A303 Amesbury to Berwick Down Scheme

PINS Reference: TR010025

Wiltshire Council Relevant Representation

October 2019

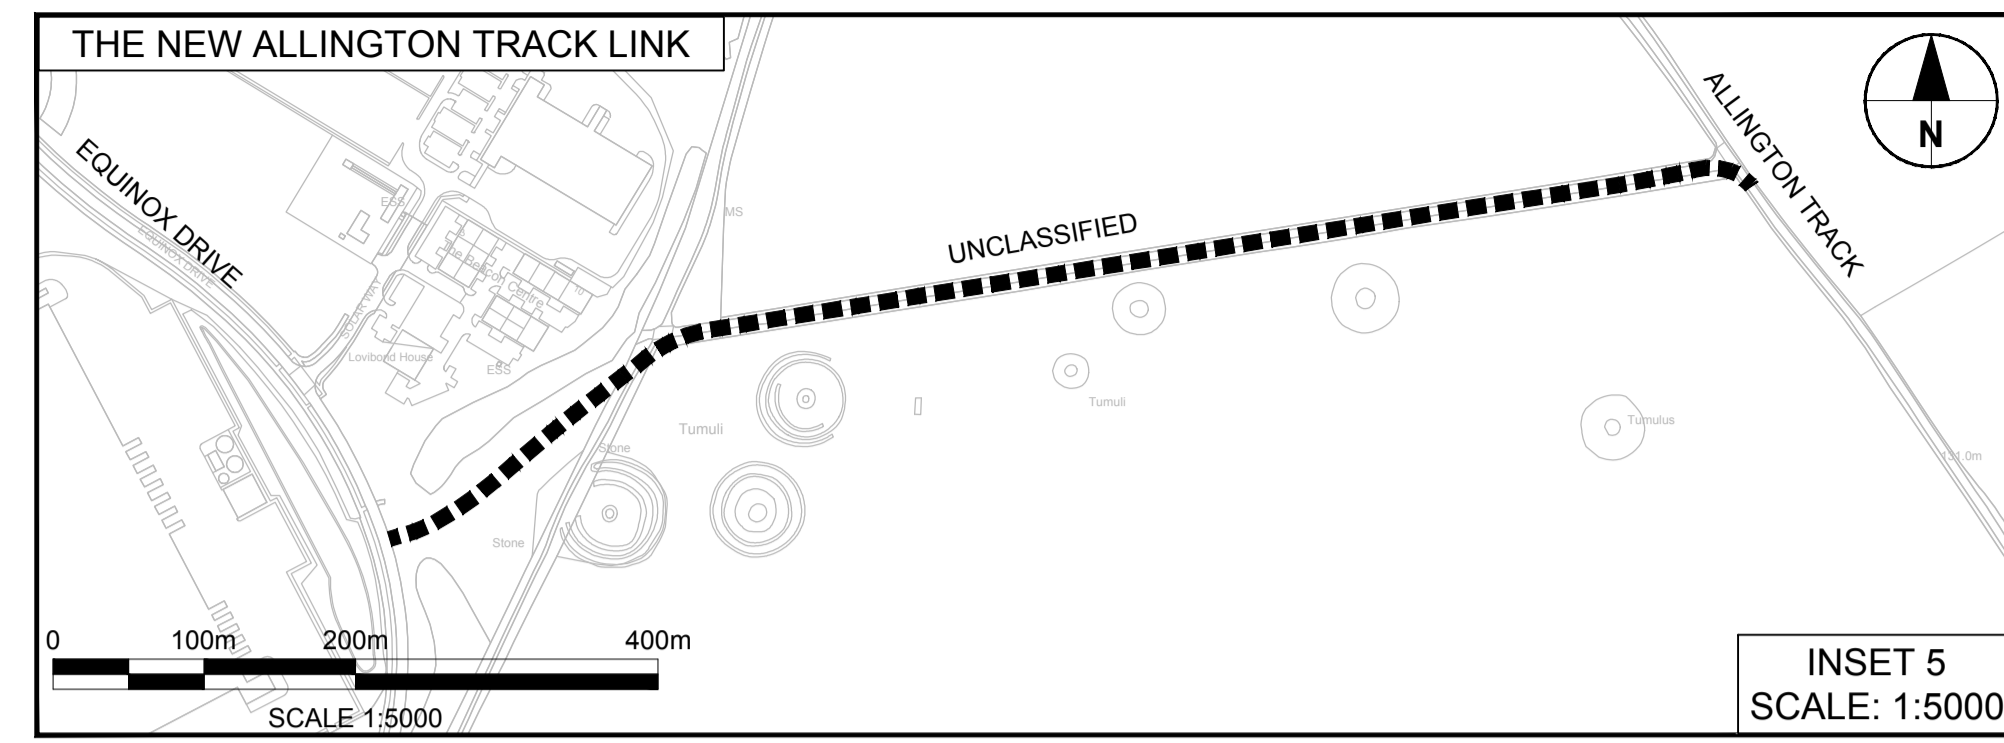
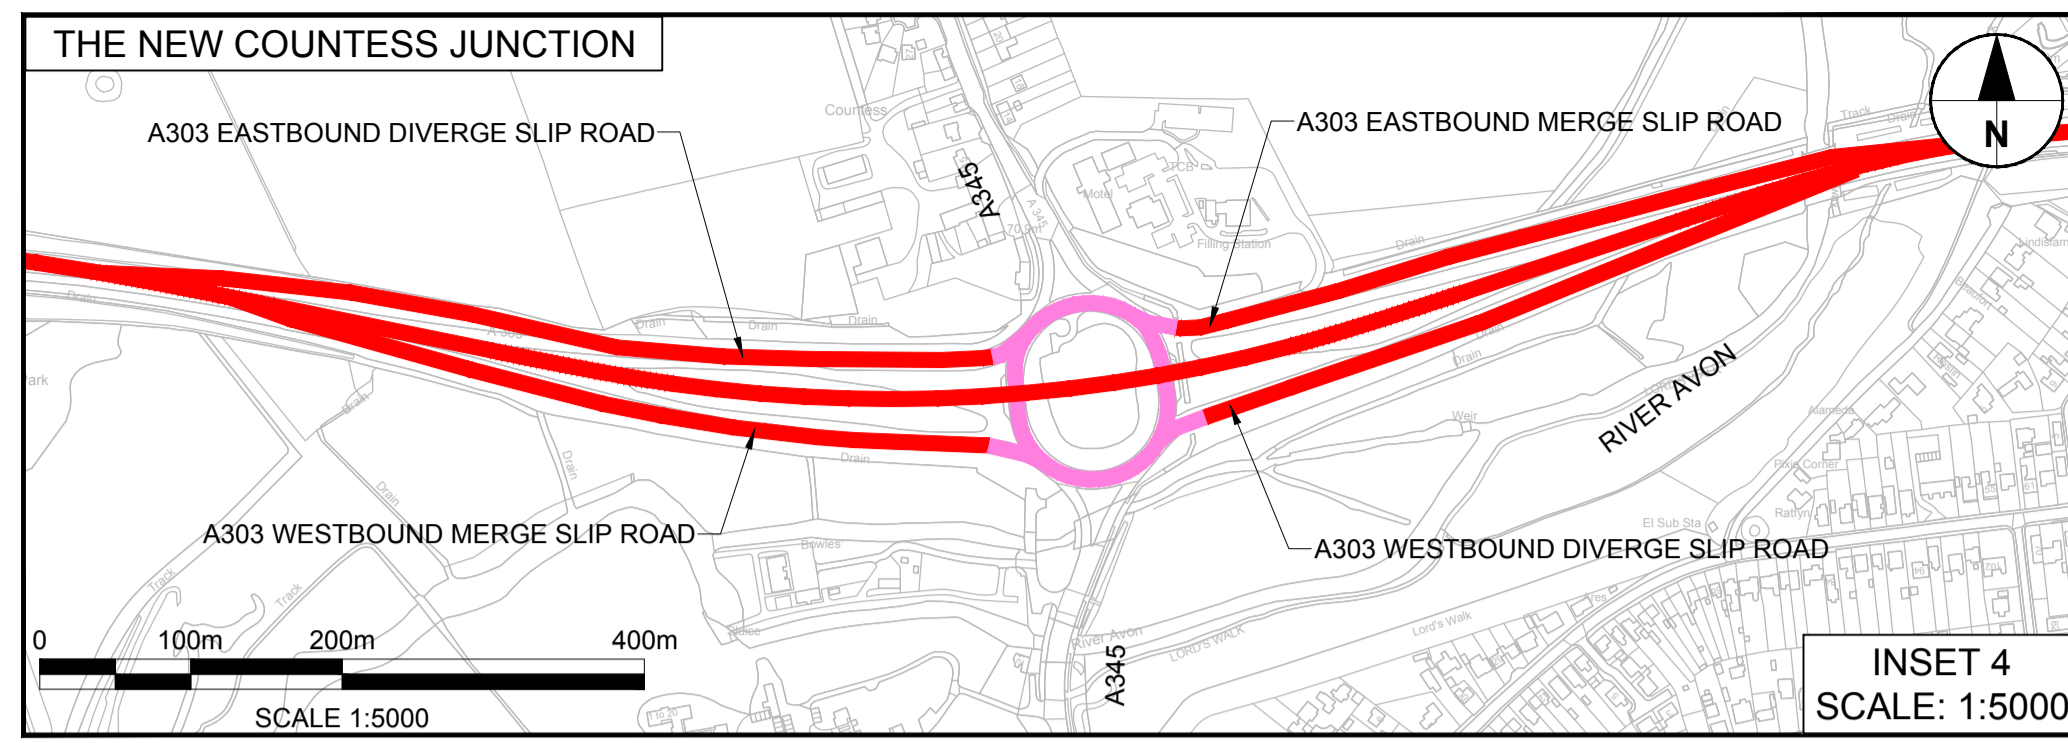
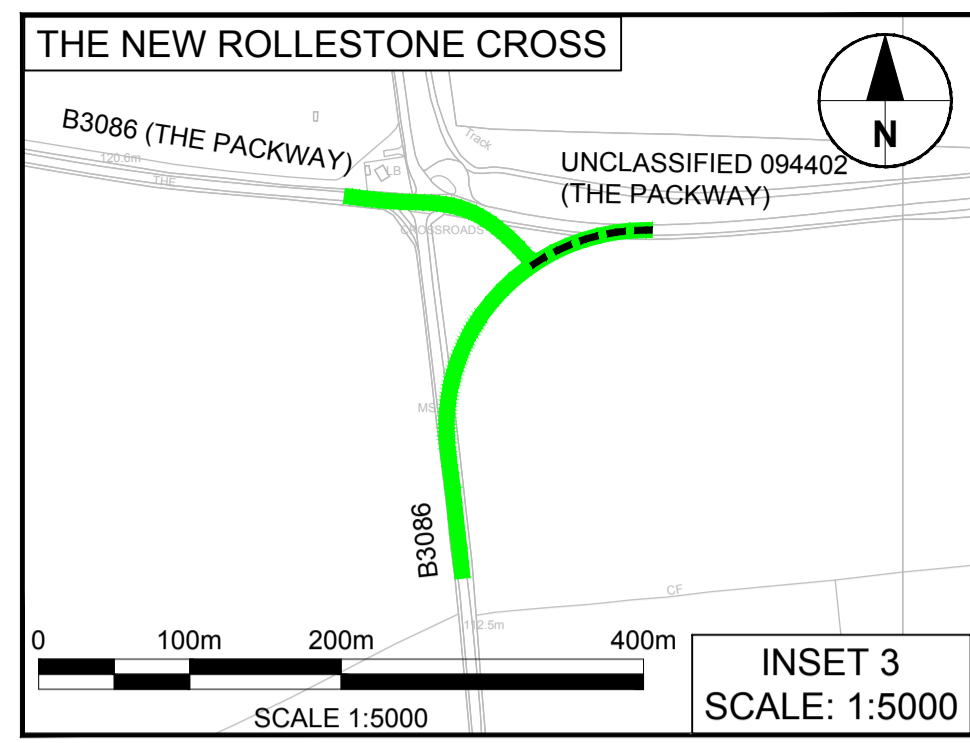
- f) The TR010025 2.13 Classification of Roads Plan does not show any information about the Countess Roundabout. It is currently classified as the A303. As a grade separated trunk road junction, the roundabout should be classified as the A345, consistent with the classification to the principal roads to the north and south. Consideration should be given to this issue in the context of those raised above.
